TIERRA WEST, LLC

February 28, 2023

Re: SW Corner of Sage & Unser TIS draft, COA comments
Traffic Impact Study, HT#M10D023
Report dated January 4, 2023
Engineer's Stamp 1/4/2023
Via email tbrown@tierrawestllc.com

DRIVEWAY B & C EXHIBIT
1:30

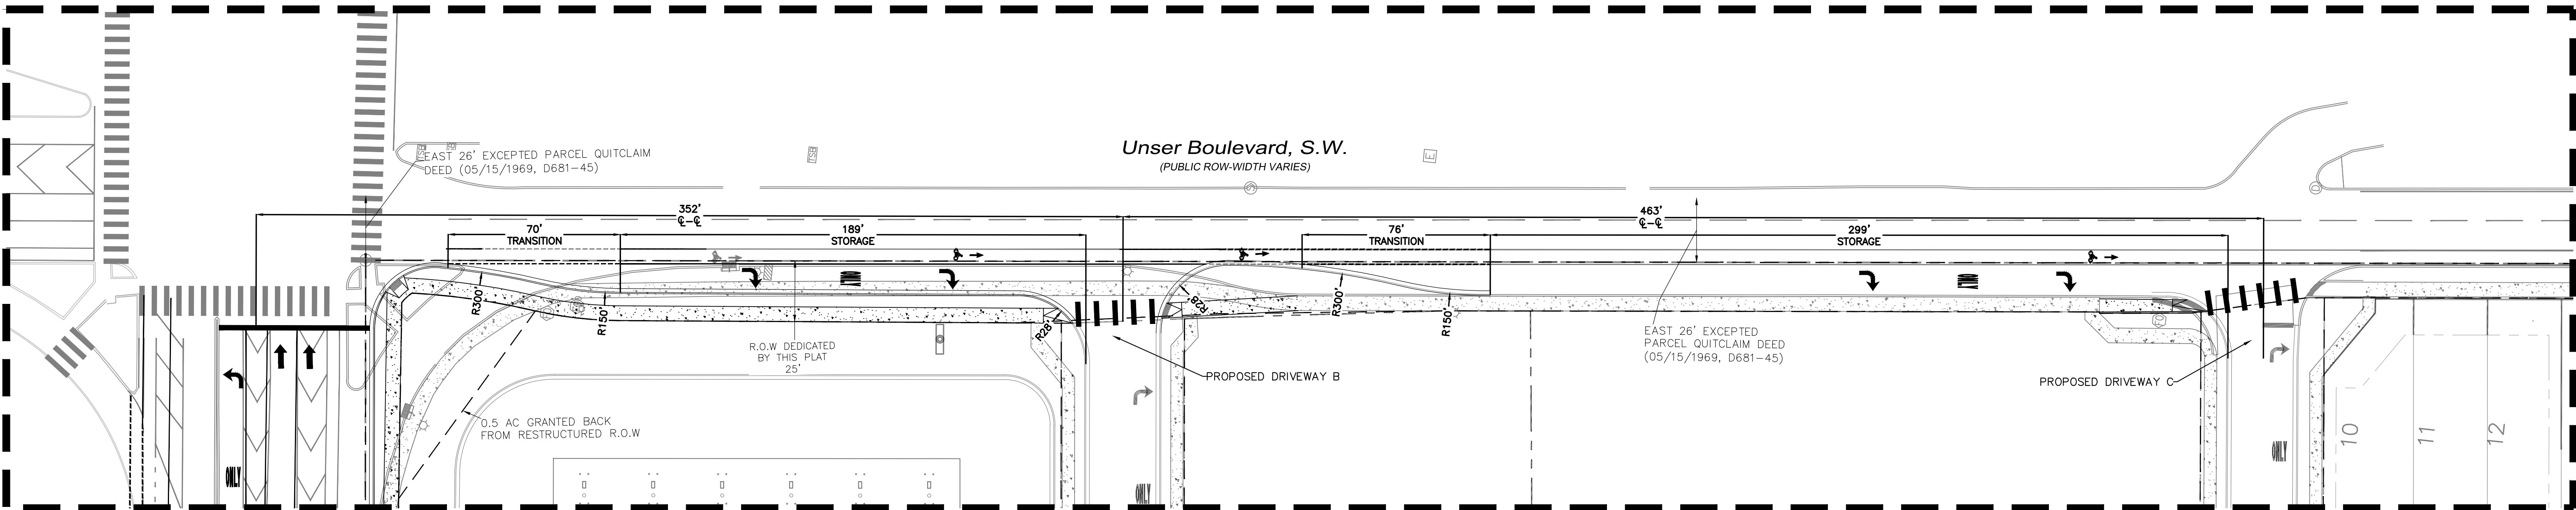
Response: This has been added to the Site Plan and updated within the report.
- Is the existing northbound channelized left-turn lane at Driveway "C" wide enough, the correct sized radii for the expected vehicles and aligned with the driveway? Are heavy vehicles anticipated to use this turn lane? Will they fit? Provide a turning vehicle template exhibit for the largest expected vehicle.

Response: A turning exhibit for the existing left-in access at Driveway "C" is provided below for a WB-50. Access widths provided at all entrances are 35-ft minimum.
